May 30, 2024

RE: Responses to Site Development Comments
Dutch Bros Coffee (CO0907)
5810 Omaha Boulevard, Colorado Springs, Colorado
City File No. PPR2413 / Our Job No. 23098

The following outline provides each of your comments in italics exactly as written, along with a narrative response describing how each comment was addressed:

Job Number: 23098  
Sheet: 11  
2019 DCA  
Financing USA, LLC

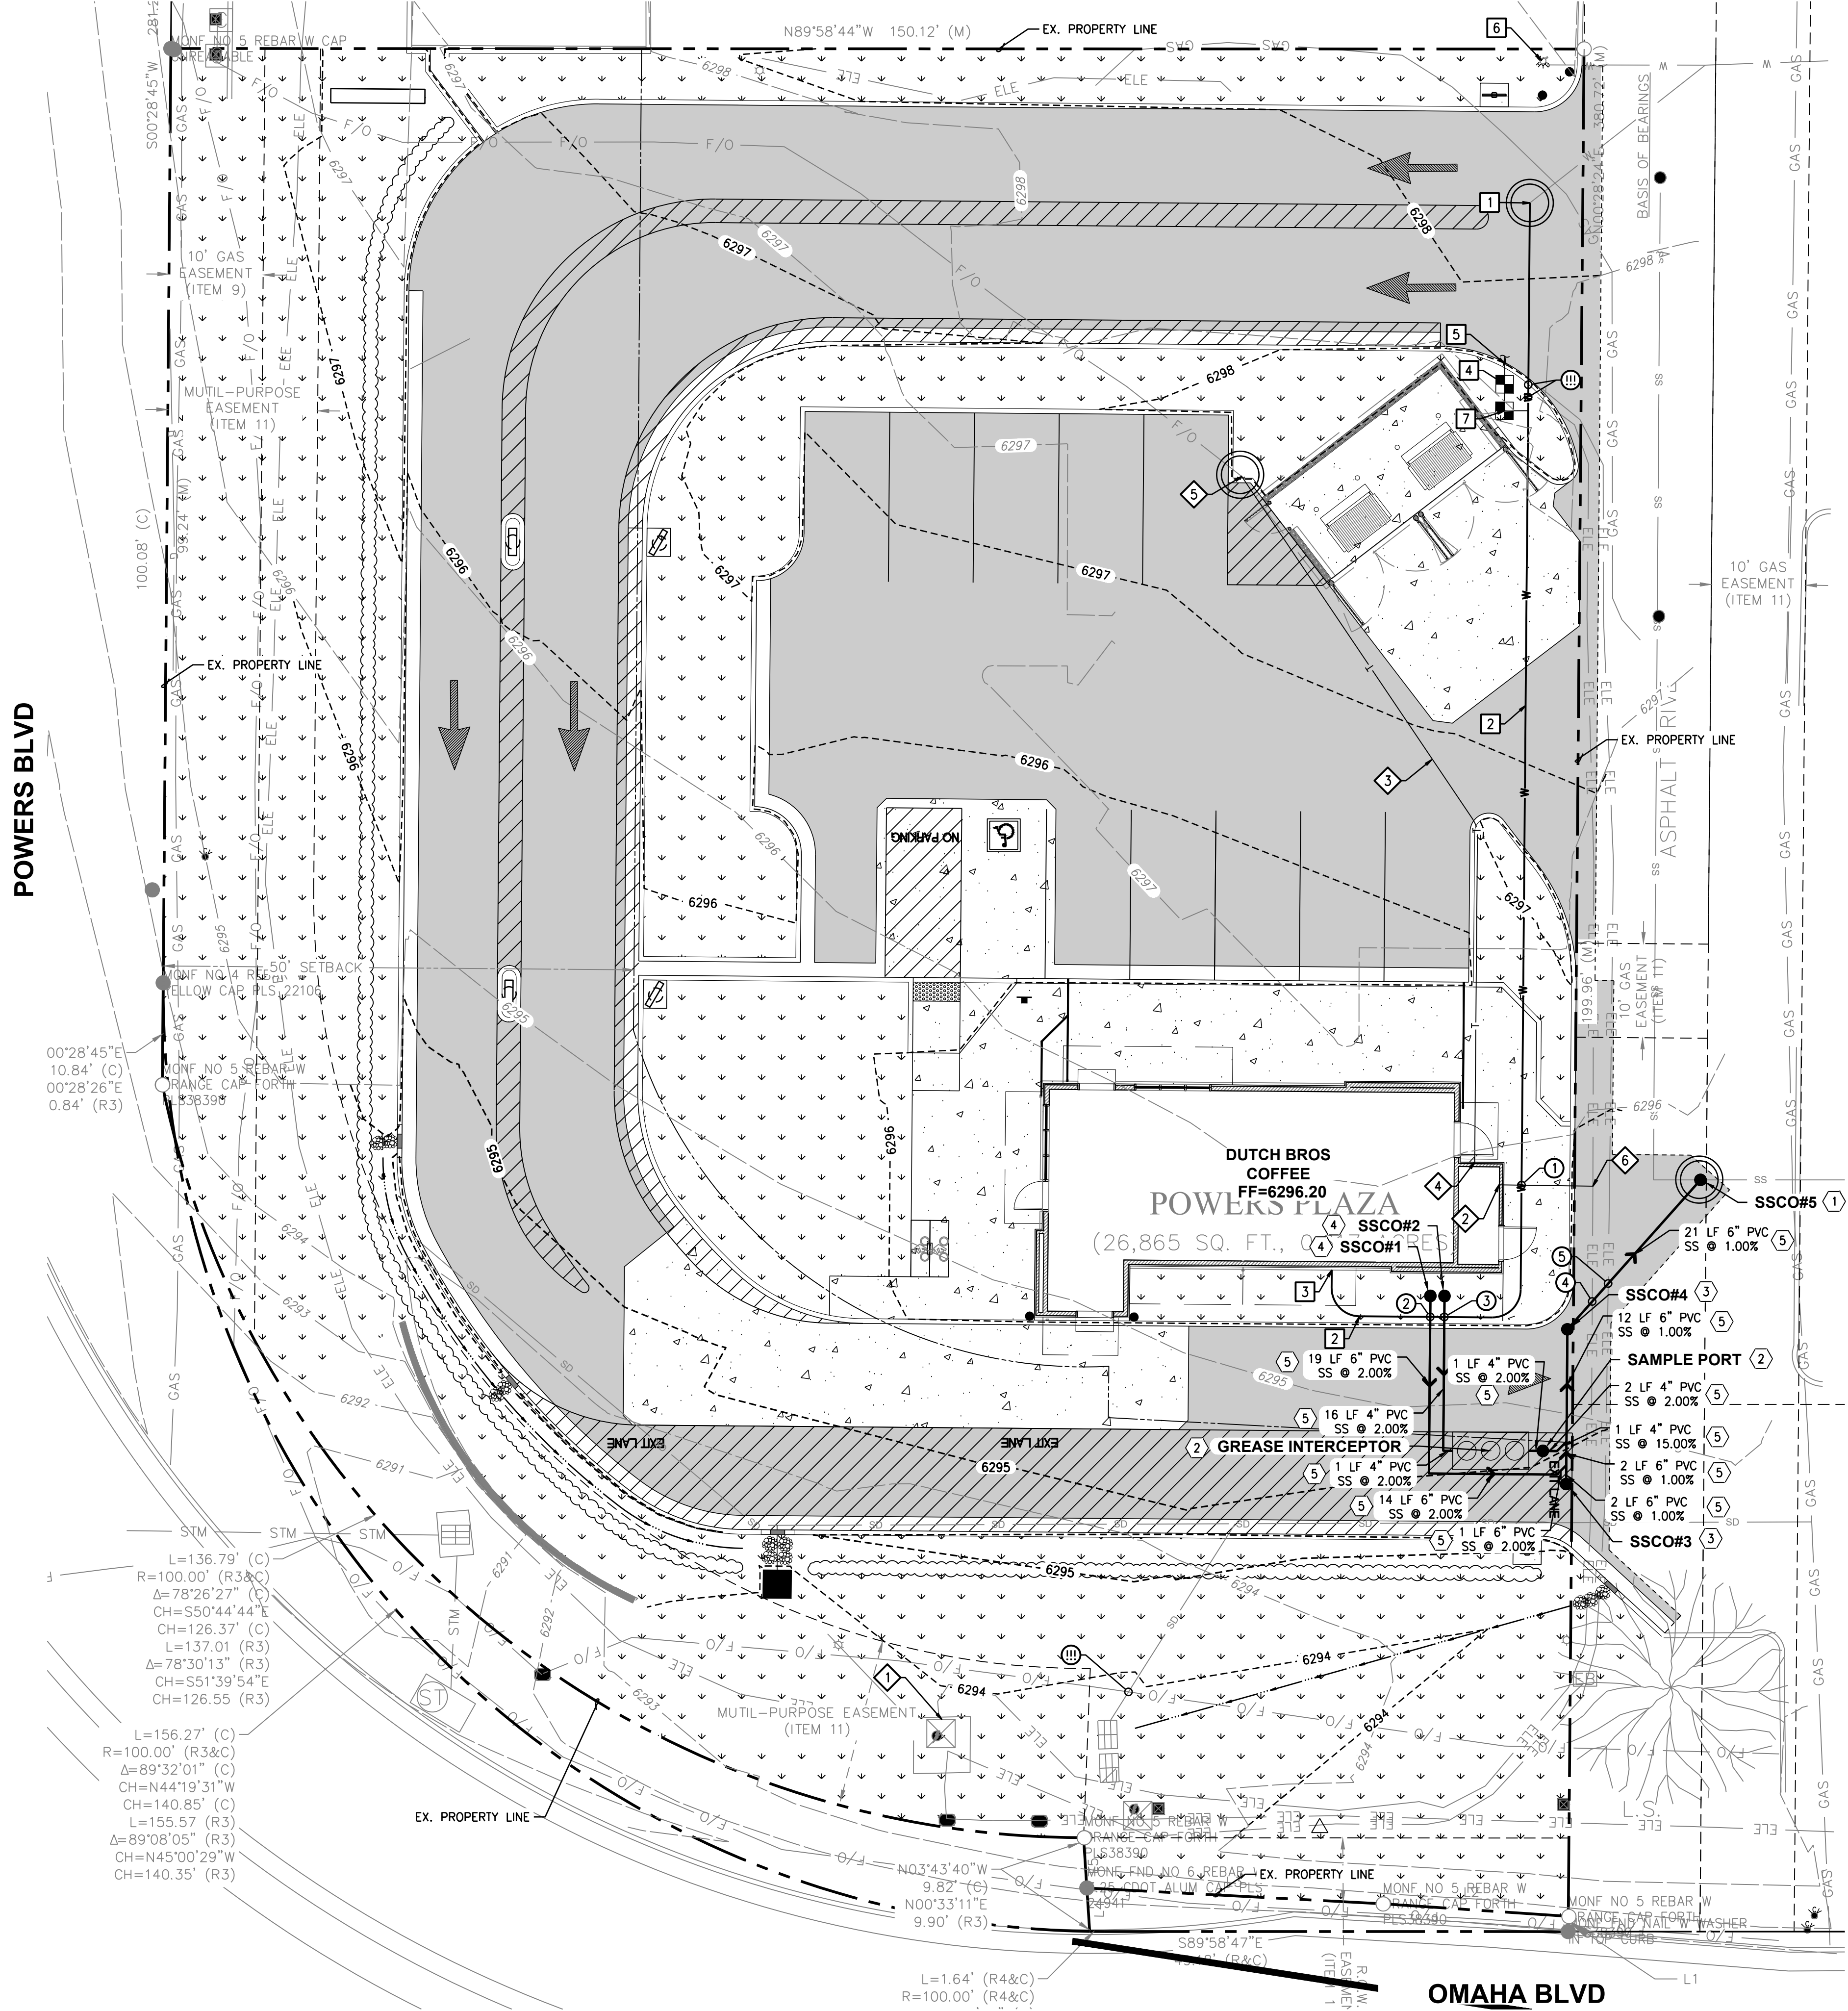
- *Remove meter pit*

- *Replace existing meter pit with new in building up to current standards*

- *Grease drop needs detail*

- *Either in SS or W construction notes explicitly express W/WW line crossings must be perpendicular to each other*

- ***Add note "Gas meters must be a minimum of 3-feet away from any opening in walls. Ensure gas meter has 3-feet radial separation from doors, operable windows, and sources of ignition."*

- ***Gas and electric meter locations on plan view and building elevations must be shown and labeled.*

Response: This comment is noted. The plans have been updated to remove the meter pit.

Response: This comment is noted.

Response: Detail of the grease interceptor was added to Sheet 13.

Response: A note has been added to the plans.

Response: A note was added to the plans.

Response: The project will not be using gas services. Please refer to the Utility Plan – Sheet 11 for the electric meter location. Dry Utility Construction Note #2 is the meter location. The meter will be located on the outside of the building.

Job Number	23098
Sheet	13
2019 DB	
Franchising USA, LLC

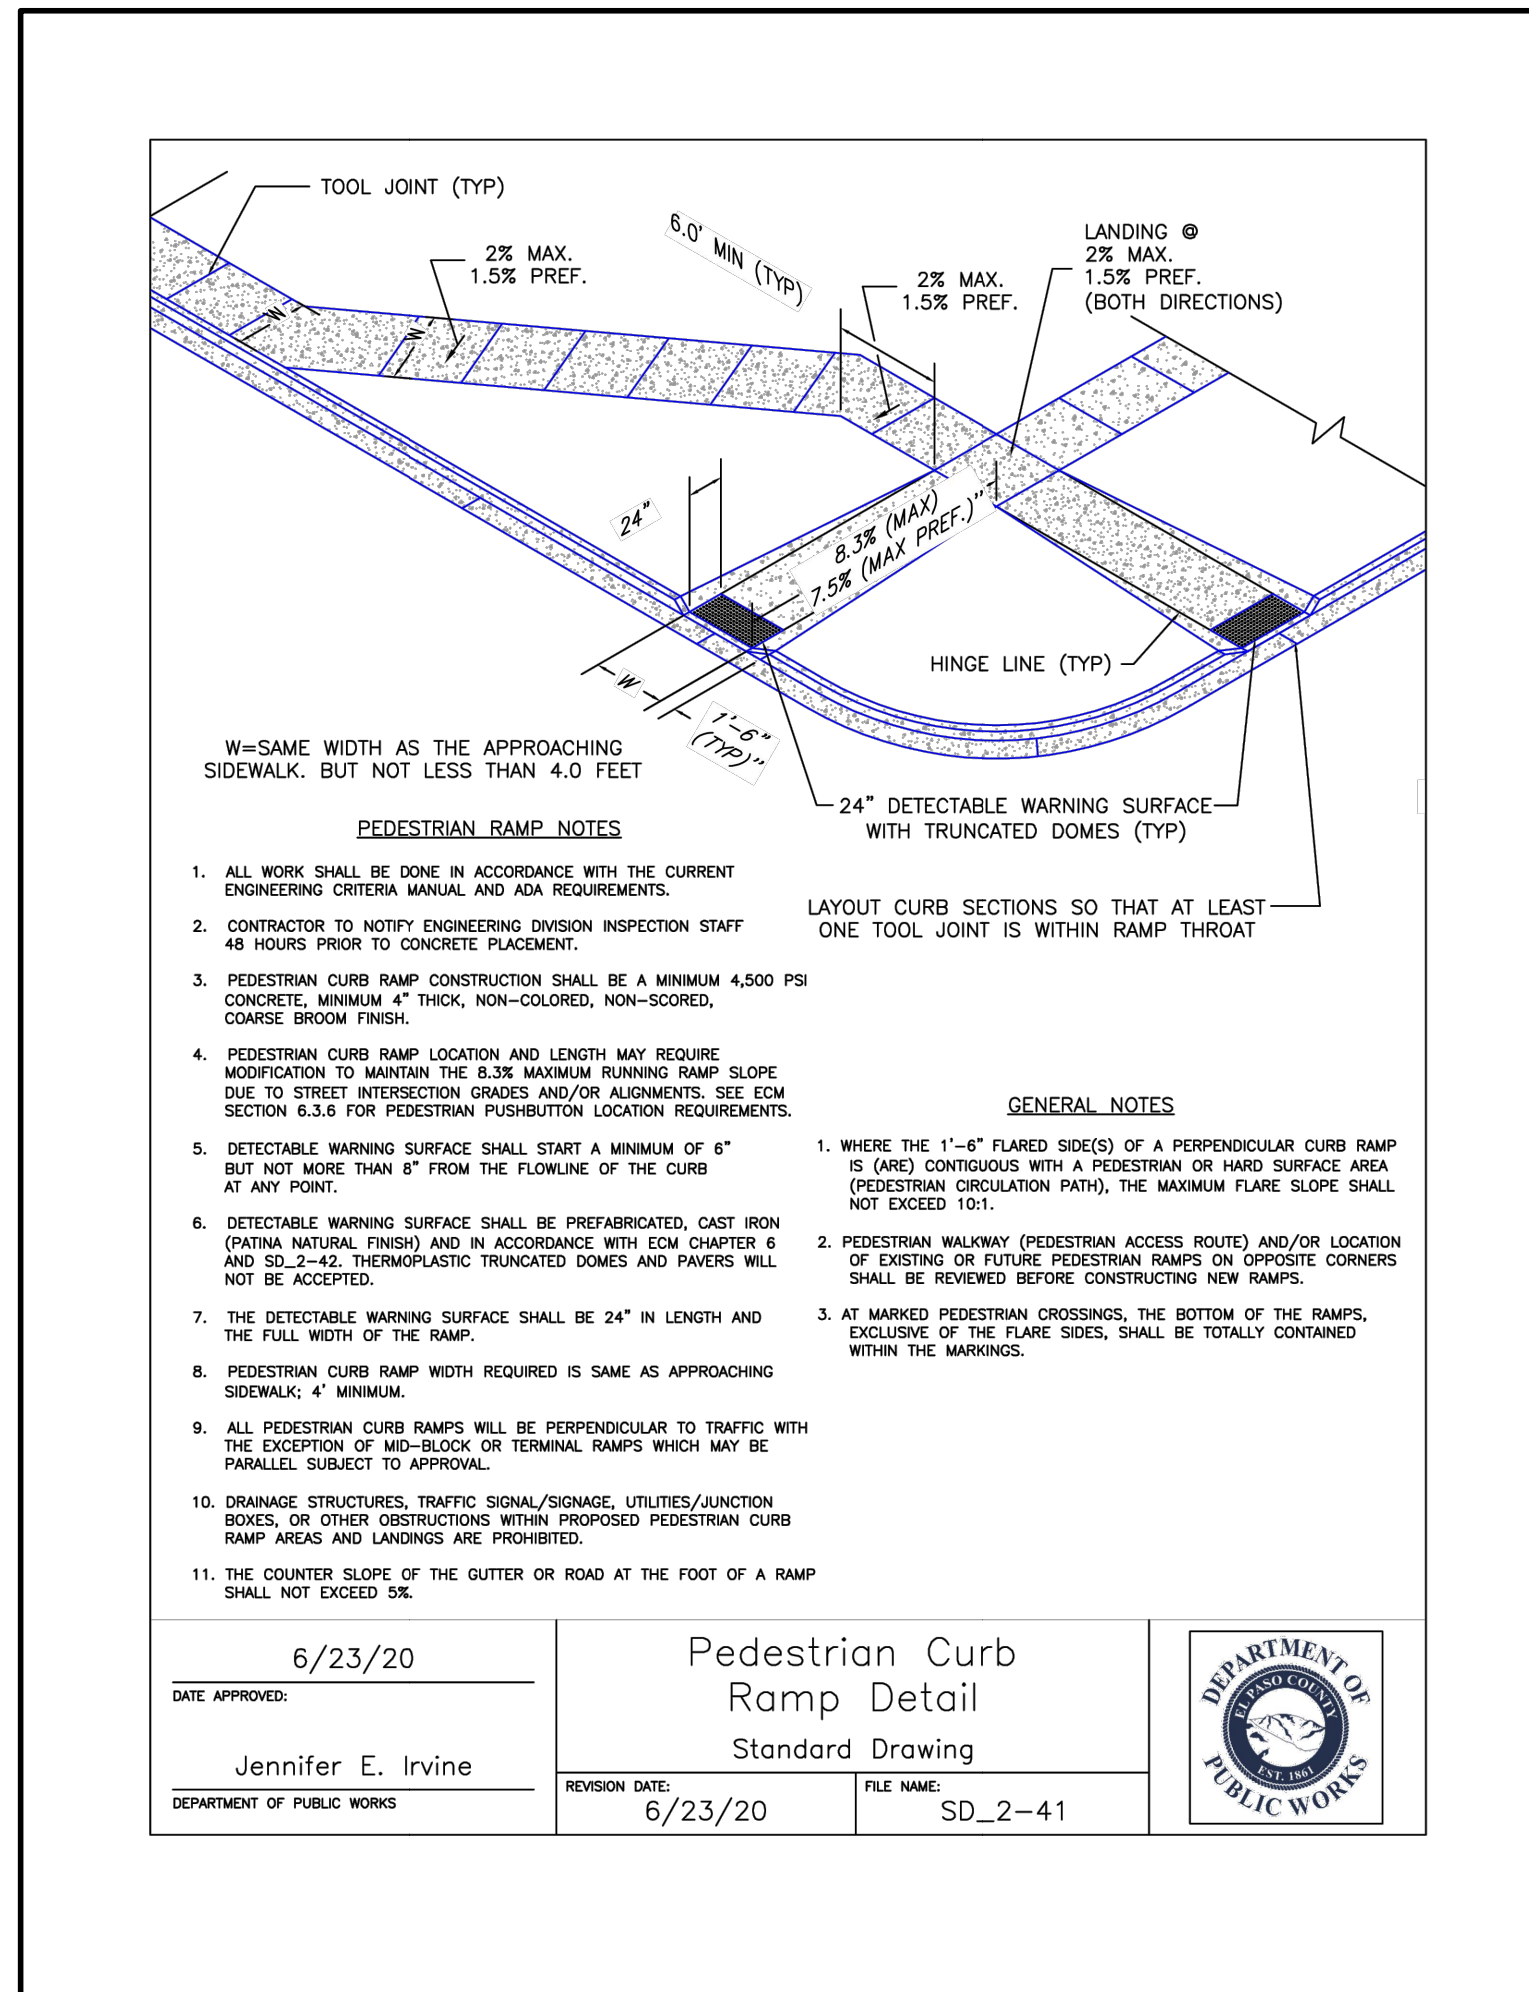
- *The Grease interceptor needs to be a minimum of 325 gallons. Provide more detailed schematic*

- *Grease interceptor needs to be a minimum of 325 gallons*

Response: This comment is noted. The grease interceptor is not a gravity grease interceptor. The grease interceptor is hydramechanic. The note for the grease interceptor has been updated and a detail of the grease interceptor has been added to the plans.

Response: This comment is noted. The grease interceptor is a hydromechanical grease interceptor. A detail has been added to Sheet 13.
